Application Reference: 2025/0591

Site Address: 13 Clarence Road, Monk Bretton, Barnsley, S71 2NL

Introduction: Demolition of existing detached garage and erection of single storey side and front extensions to dwelling.

DRAWING NO. : 2025.02.P6

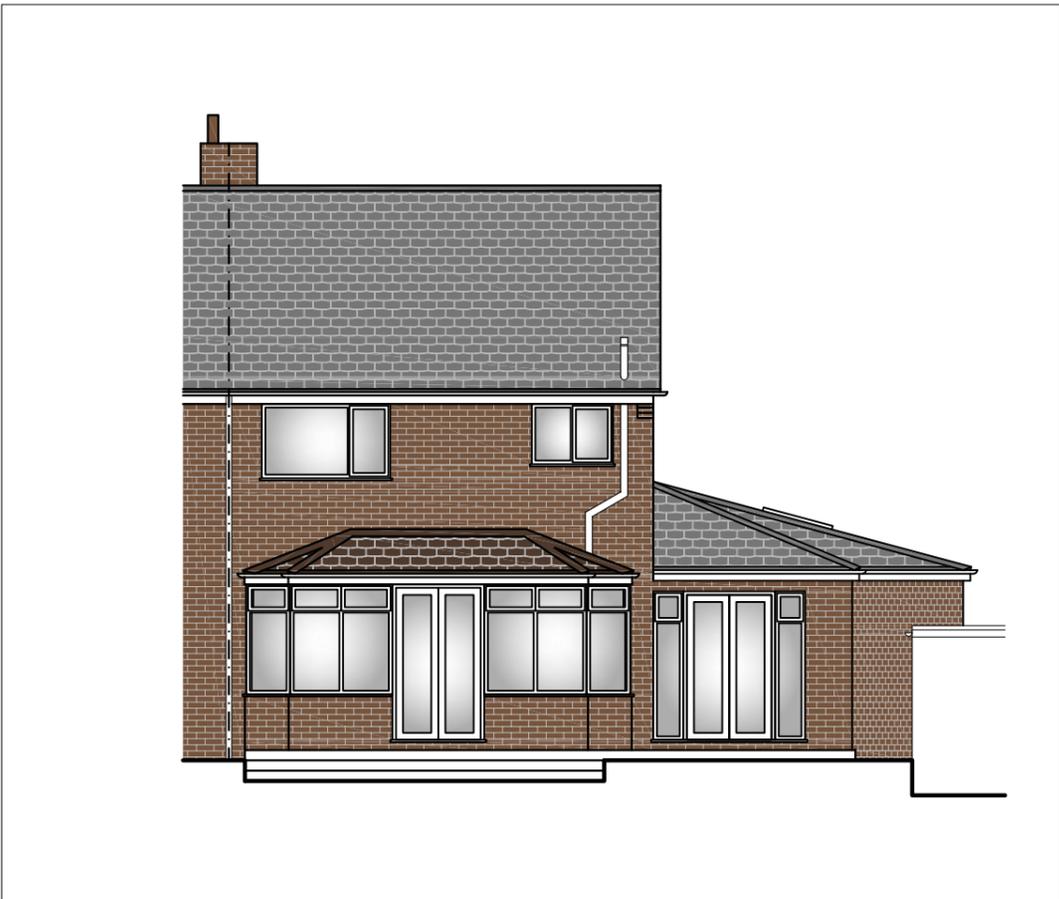
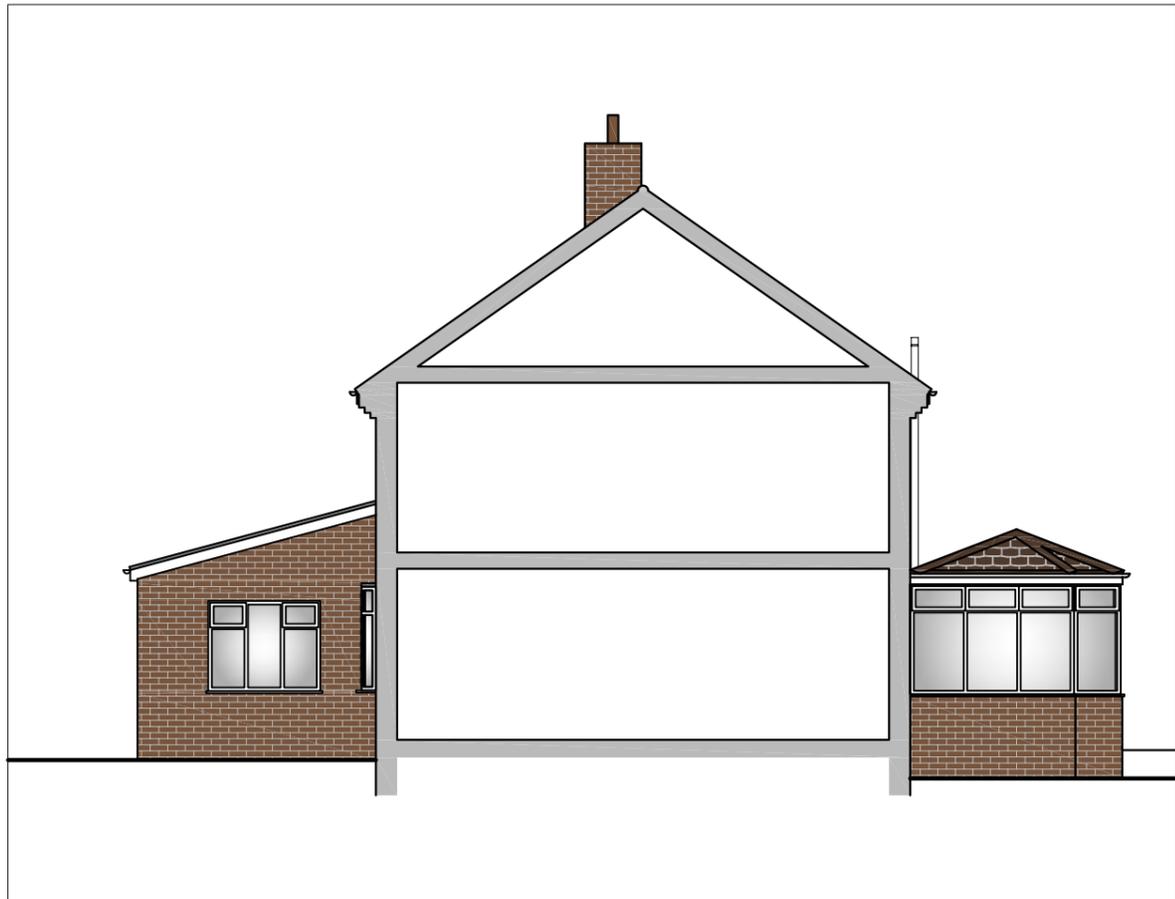
The proposed front extension has been reduced from the initially submitted plans to provide a forward projection of approximately 1.8 metres, in line with similar front extension on the

A reduction in the projection of the front extension was requested in order to provide a front projection which would be consistent with that of other front extensions in the street scene.

DRAWING NO. : 2025.02.P6A

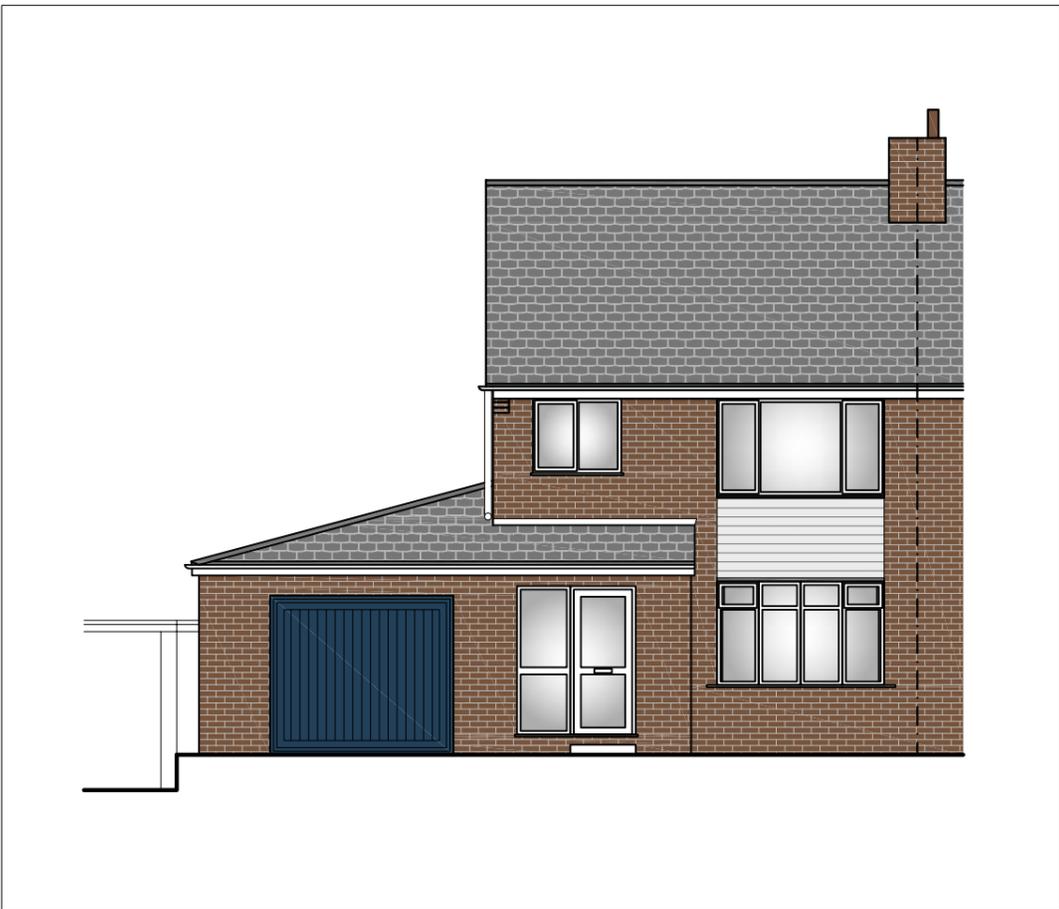
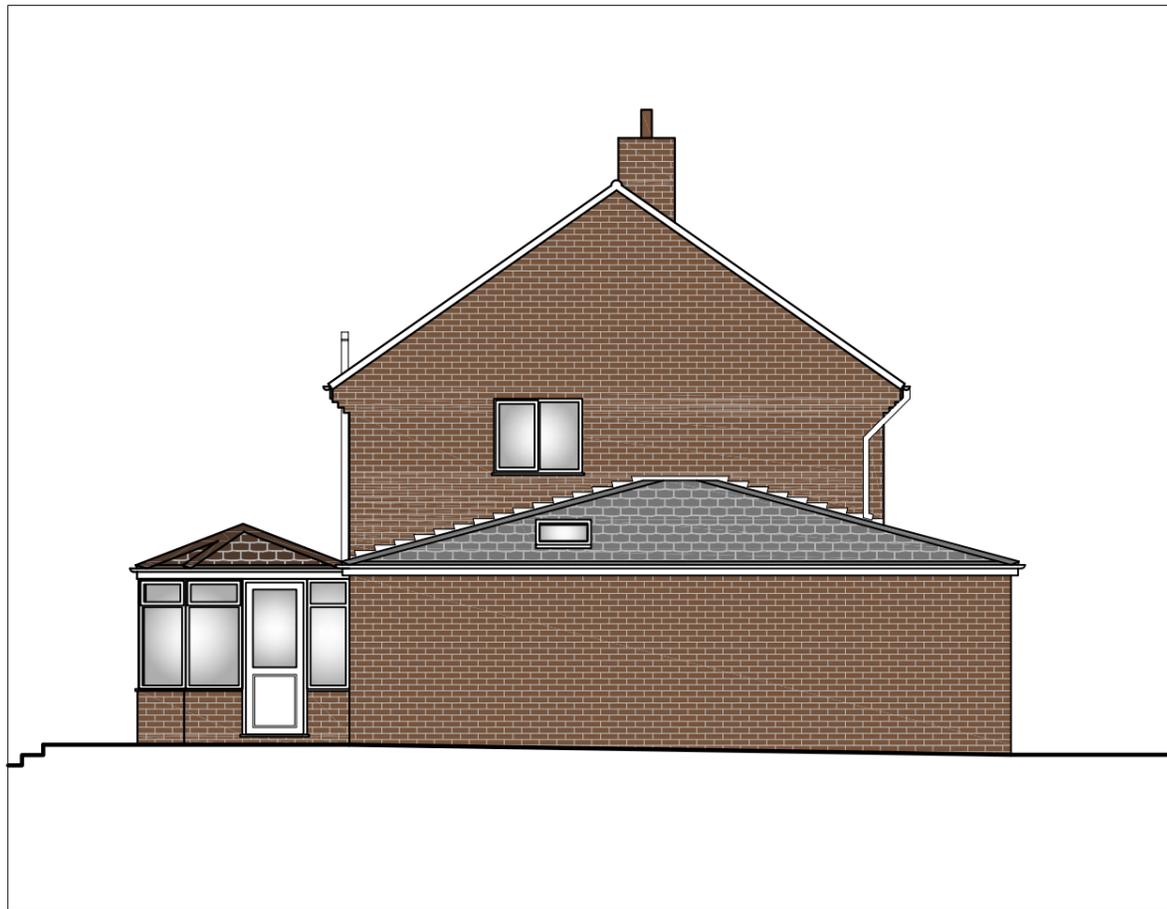
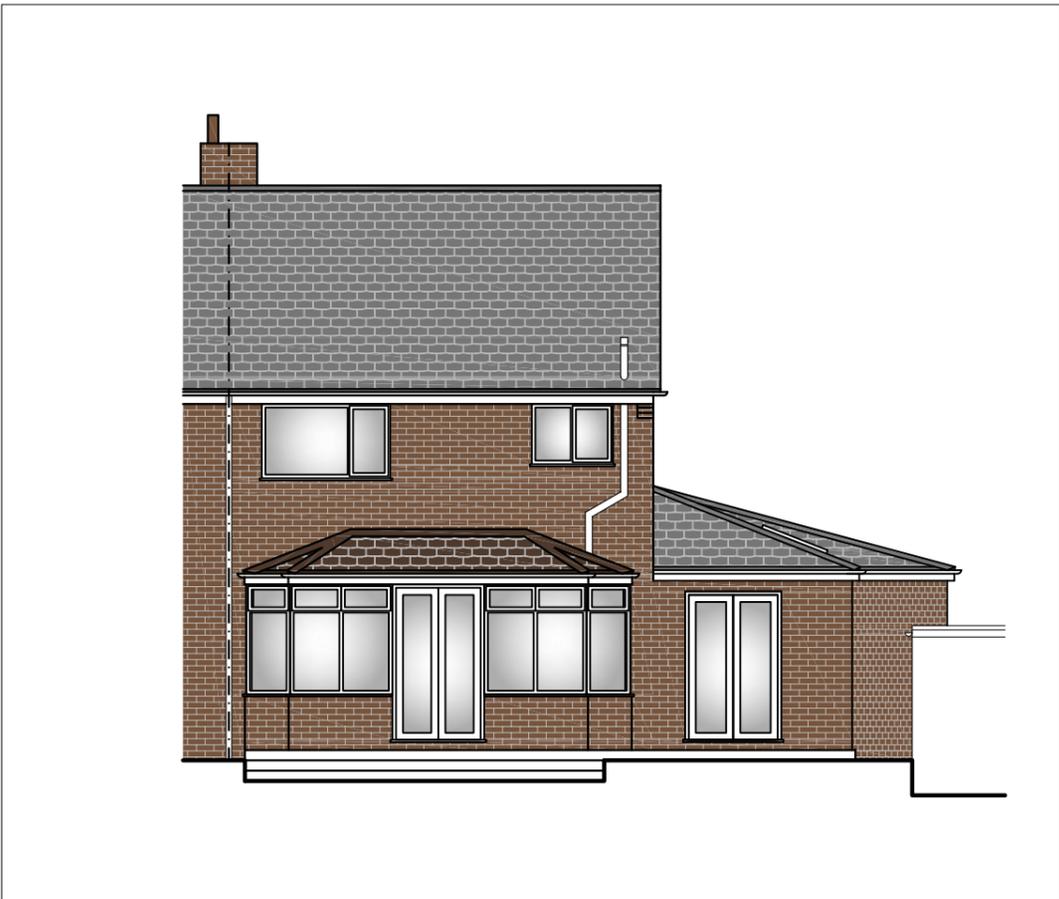
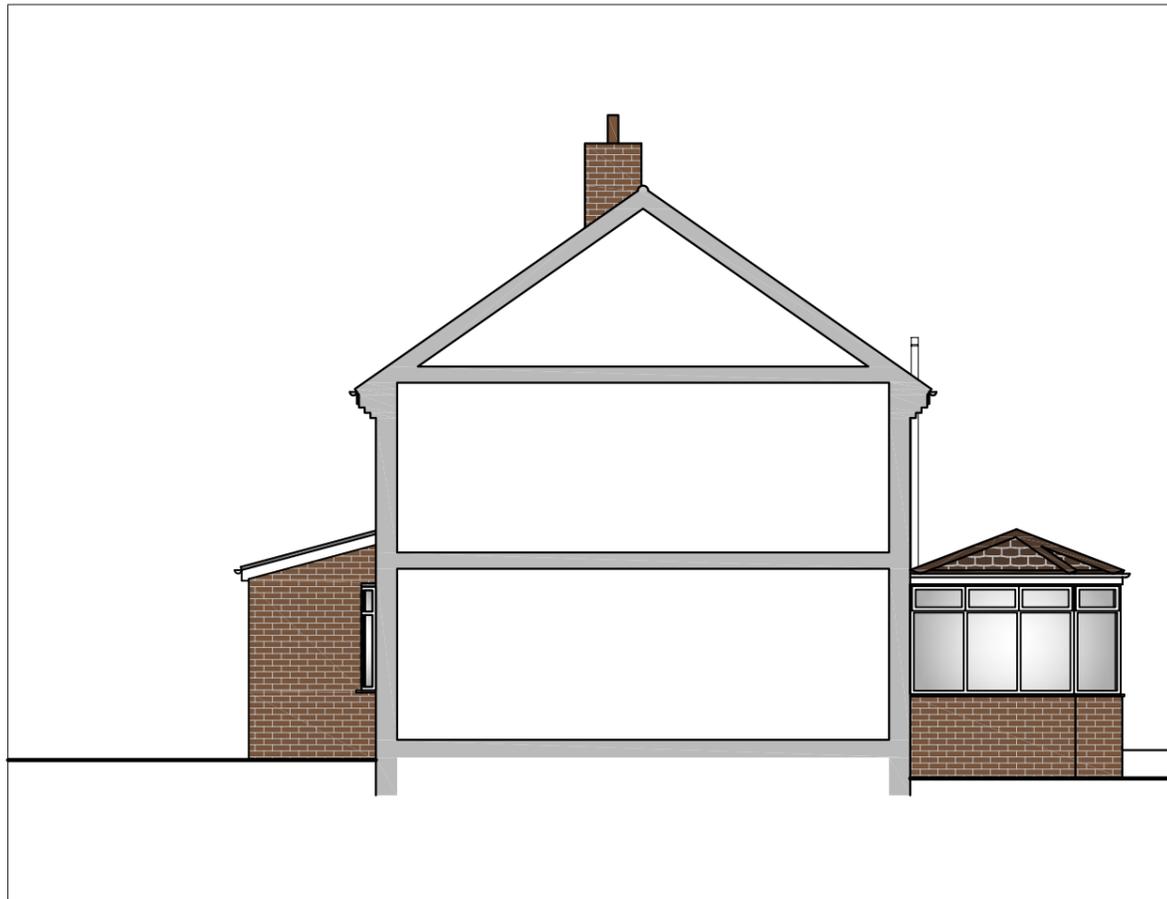
street scene. This projection is considered to be a more suitable and complementary proposal and remains subordinate to the dwelling. The use of a lean to roof form allows the porch to be integrated into the proposed side extension and is preferred to other flat roofed extensions in the street. The proposed front door with integrated window sits symmetrically to the porch and provides matching fenestration to the existing front door.

The proposed side extension provides a sideways projection of approximately 4.2 metres at the front. This projection is reduced down to 2.9 metres at the rear. Although the projection at the front exceeds two thirds the width of the existing dwelling, which would not normally be permitted under the House Extension SPD; multiple side extensions in the street scene provide similar projections abutting neighbouring boundaries. On this occasion the projection would therefore be considered acceptable. Additionally, a larger garage frontage provides increased internal garage space to allow for waste bin storage. The proposed garage door is detailed symmetrically to the extension. The use of a hipped roof is preferred to neighbouring flat roofed extensions and is more in keeping. Although a pitched roof would be more replicant of the existing dwelling, the use of a hipped roof allows for a less dominant proposal.
